STATE OF NORTH CAROLINA  
DEPARTMENT OF TRANSPORTATION

**Addendum No. 1**

RE: Contract ID: C201712  
WBS# 5CR.20321.5  
Durham County  
21 Sections of Secondary Roads

**January 16, 2007 Letting**

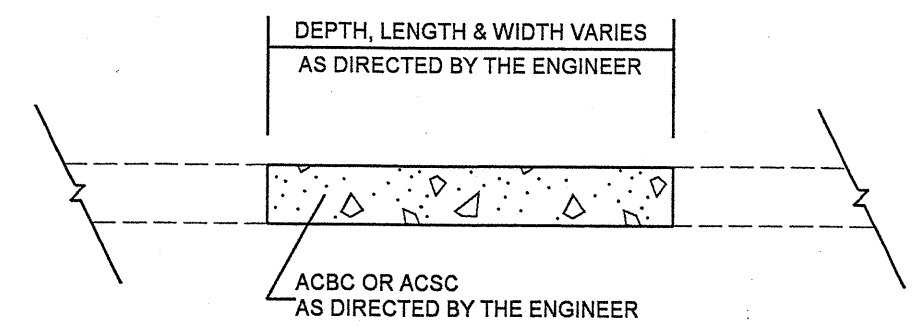
On Sheet No. 10 the Pavement Schedule was revised for Symbol "V2". Please void Sheet No. 10 in your Sketch Maps and staple the revised Sheet No. 10 thereto.
